**KIRKLEES METROPOLITAN COUNCIL  
INVESTMENT & REGENERATION SERVICE**

**DELEGATED DECISION TO DETERMINE APPLICATIONS FOR  
NON-MATERIAL AMENDMENTS**

<b>Reference No:</b>	2026/NM/91085/E
<b>Site Address:</b>	Land off, Bankwood Way, Birstall Retail Park, Birstall, Batley, WF17 9DT
<b>Description:</b>	Non material amendment to previous permission 2024/91591 for variation of conditions 2-6, 15 and 29 on previous permission 2021/92528 for erection of retail development, associated parking, servicing areas and landscaping
<b>Recommending Officer:</b>	William Simcock

This Minor Non-Material Amendment application seeks to modify the approved elevations and floor plans for the Home Bargains retail unit as listed in the plans and specifications schedule of the decision notice.

E01 RETAIL UNIT - EAST ELEVATION  
1: 100

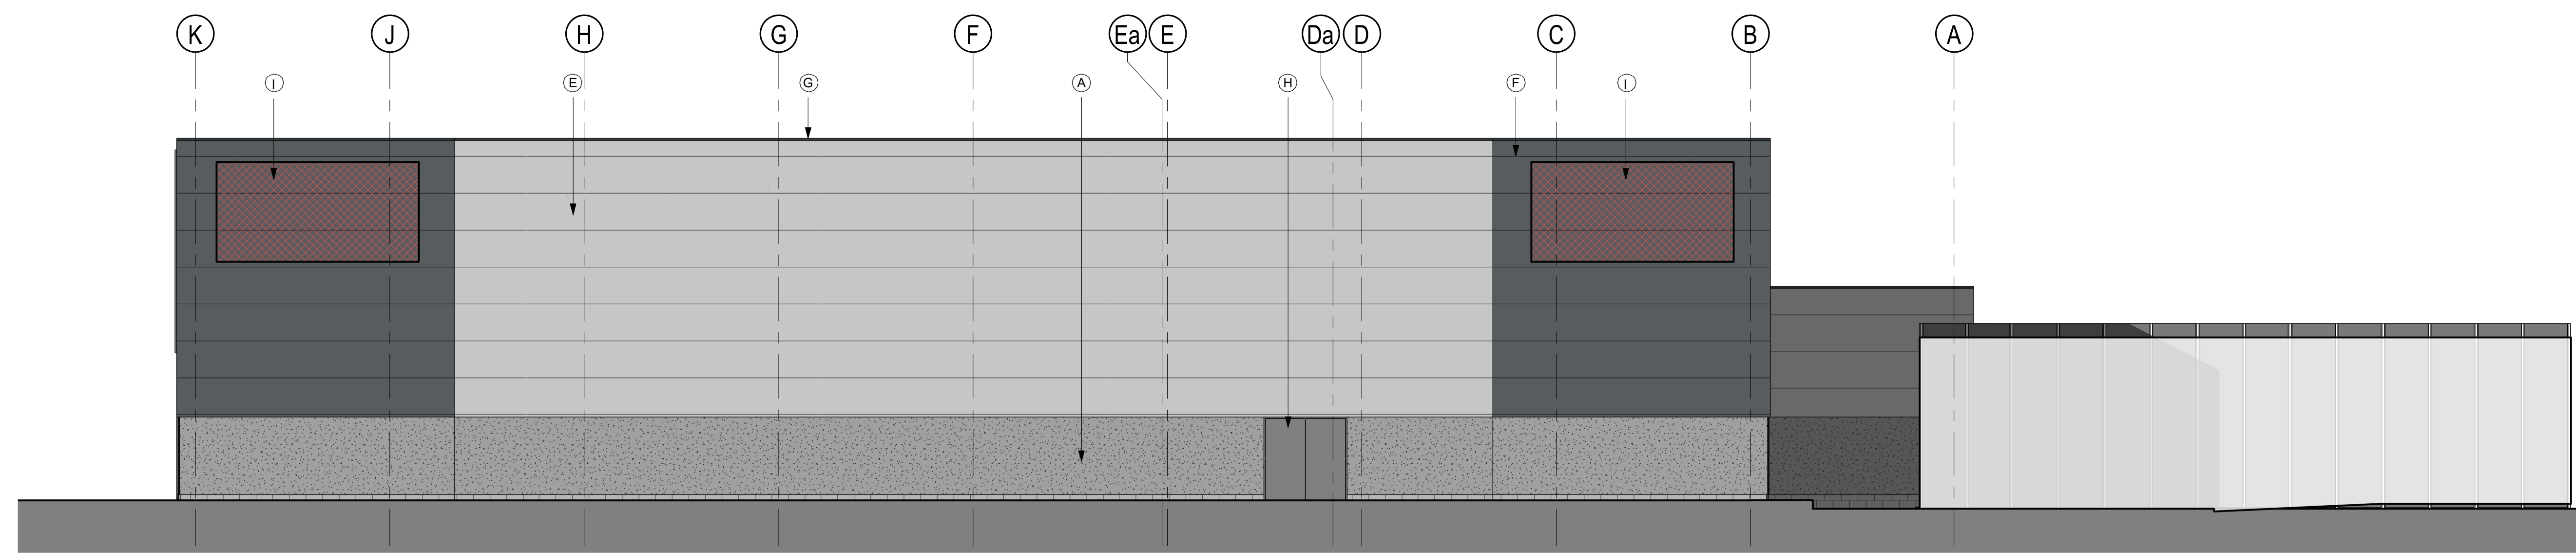
1. Introduction of additional glazing to the store frontage (eastern elevation);
1. An additional door to the rear of the store (southern elevation);
2. A slight extension of the darker wall cladding on the western elevation.

The glazed area would be the same height but extended in length to 21m, forming four bays divided by solid pillars faced in anthracite grey cladding. The anthracite clad part of the eastern elevation would be extended upwards above the first two window bays to within 300mm of the roof. Originally the glazed area plus anthracite-clad surround was to have been 7.5m wide and 7.2m high. The area of dark cladding on the western elevation would be increased in length from 6.3m to 16m. The footprint and layout of the building is unchanged.

YES. While the area of glazing on the front elevation would be enlarged, it would remain a secondary feature of the elevation, being contained to the ground floor and not dominating the front elevation. The proposed change does not result in any increase in the height or footprint of the building and is therefore considered inconsequential in terms of scale.

It is considered that the change would not result in a detrimental impact; indeed, the partial substitution of materials and finishes and increased glazing to the eastern (front) elevation would add visual interest and is considered to result in an improved design overall. It is considered that it would not result in any impact on residential amenity since the area is a commercial one and no residential properties would be close enough to be affected.
